Your Ref	SSD-64916225
Our Ref	NCA/19/2023
Contact	Paul Sartor
Telephone	9806 5740
Email	psartor@cityofparramatta.nsw.gov.au

COUNCIL SUBMISSION

NOTICE OF EXHIBITION OF ENVIRONMENTAL IMPACT STATEMENT FOR THE WSU INDIGENOUS CENTRE OF EXCELLENCE (171 VICTORIA RD, PARRAMATTA)

Figure 2 - City of Parramatta Council stormwater drainage system diagram.

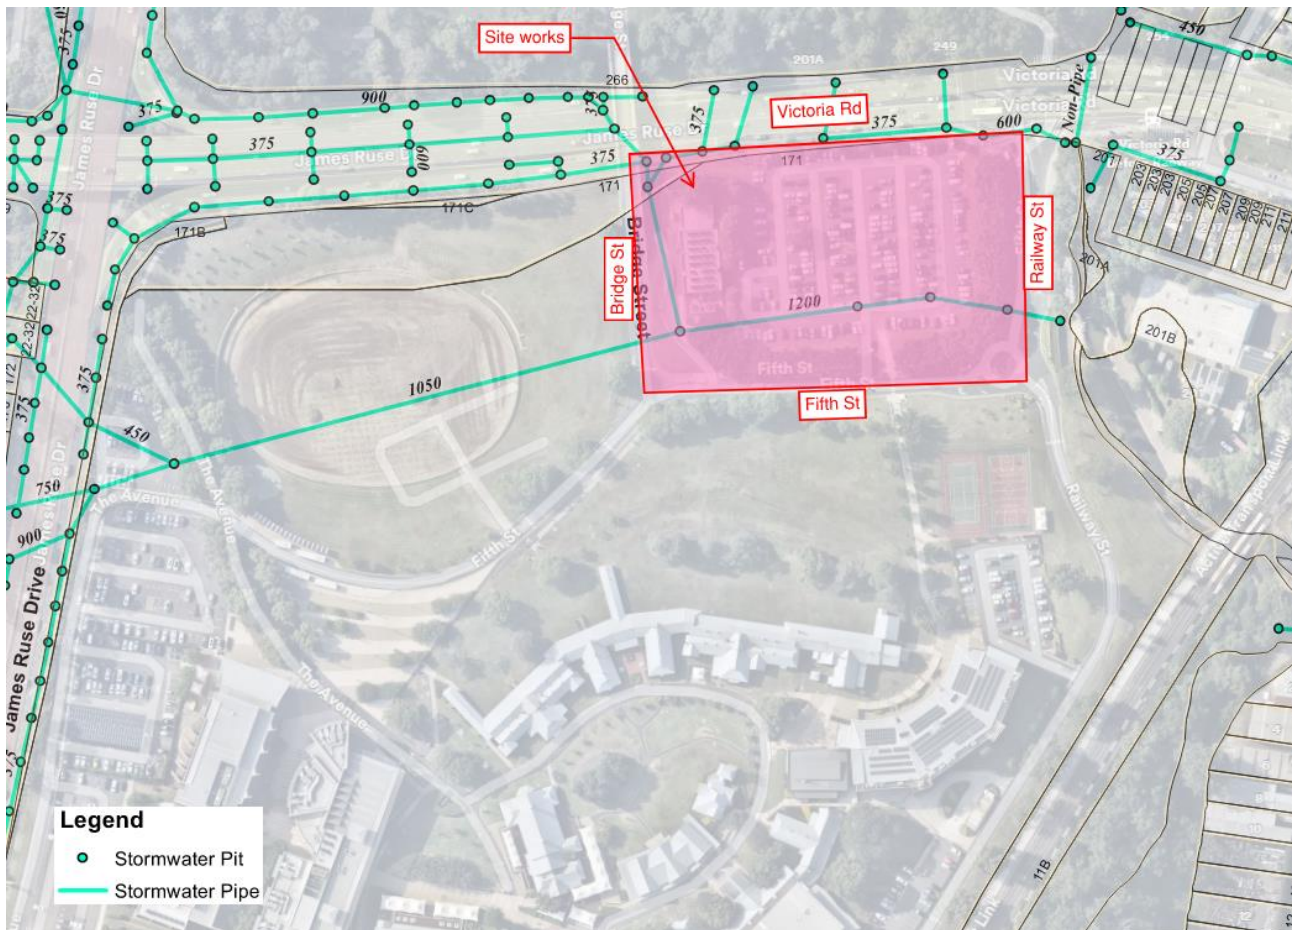
- Suspended slabs are not supported for overland flow flood mitigation.
- Building over the existing Council Stormwater pipe is not supported as this does not allow access for maintenance in the future. This pipe must be relocated by the applicant with a set of civil and design drawings of the relocated pipe submitted as part of this application. It should be shown on architectural and landscape plans to ensure that there is no future conflict.
- Unobstructed overland flow paths must be provided for the 1% AEP flow event.

2. Proposed Signage Zone

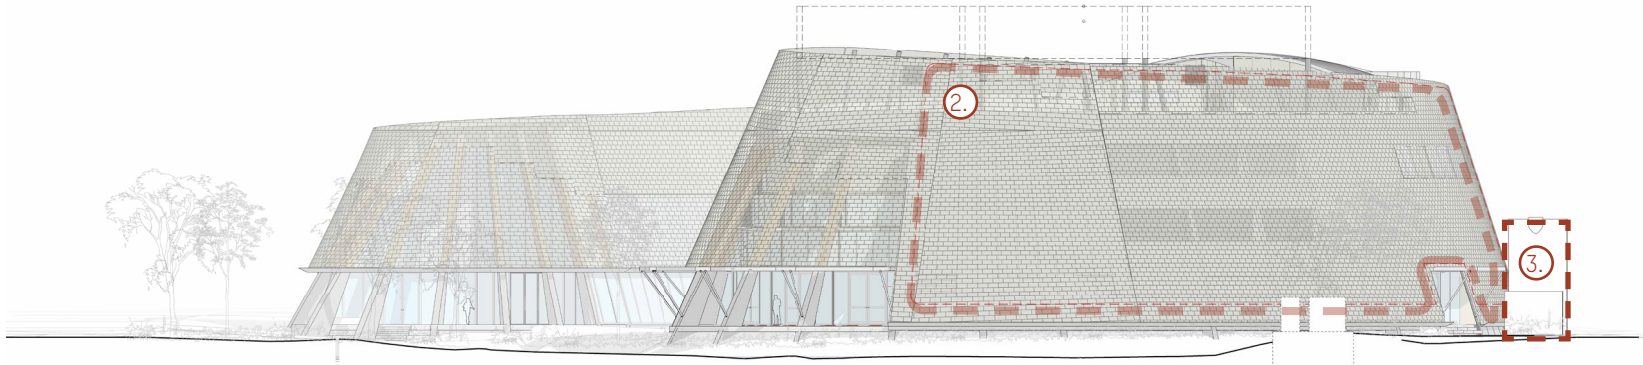
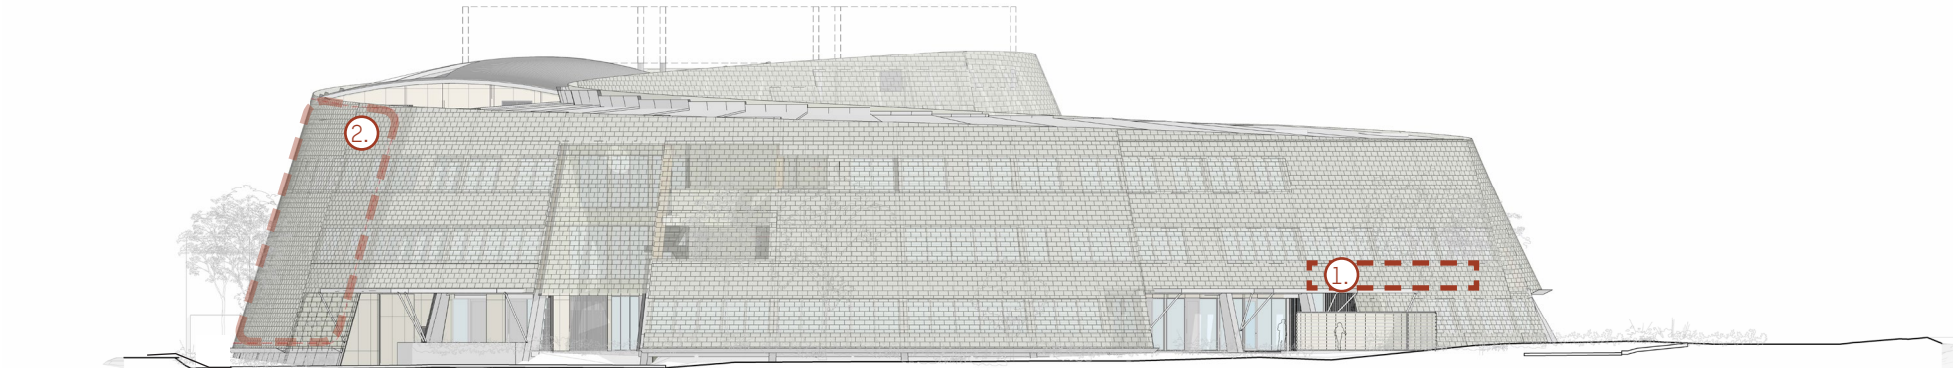
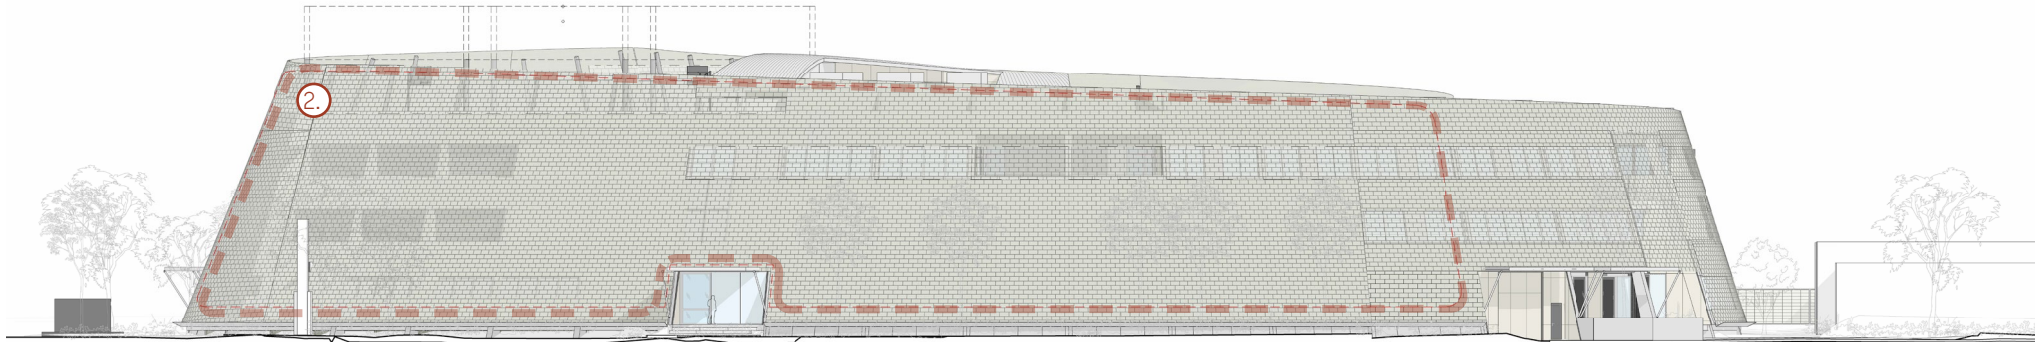
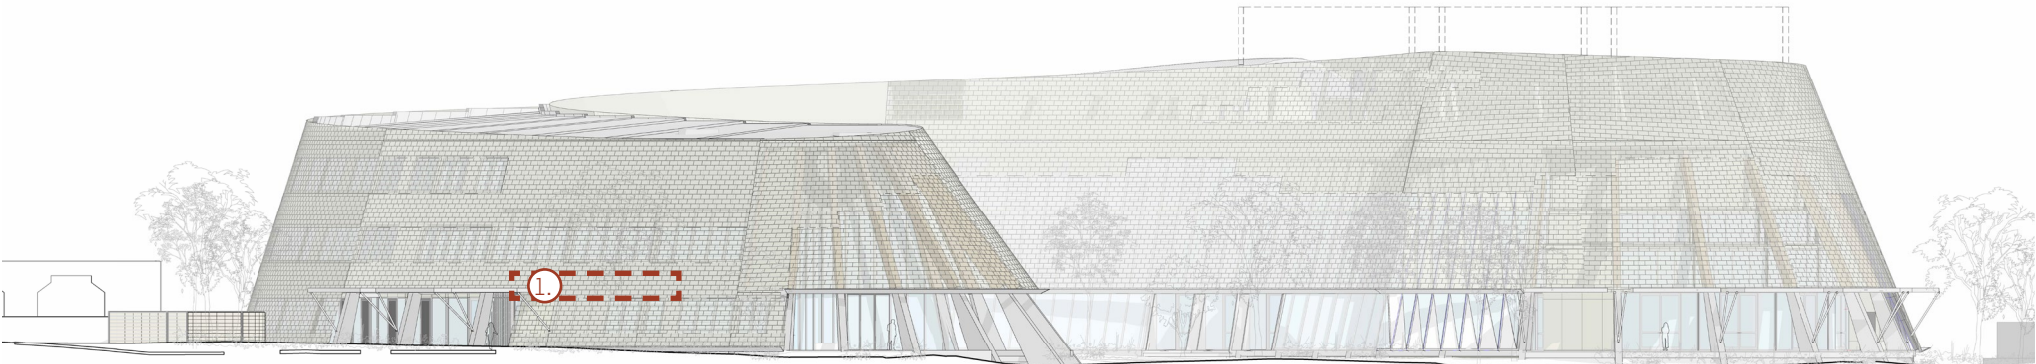
- The proposed signage zone is of a significant size, taking up a considerable amount of the length of the Victoria Road façade and all the height of the proposed building. It is unclear in the documentation provided the size or type of signage being proposed, but there is the potential for this signage to eclipse the built form given the scale of the signage zone, which may not be sympathetic to the building form or the surrounding context. It is recommended the signage zone be reduced in size.
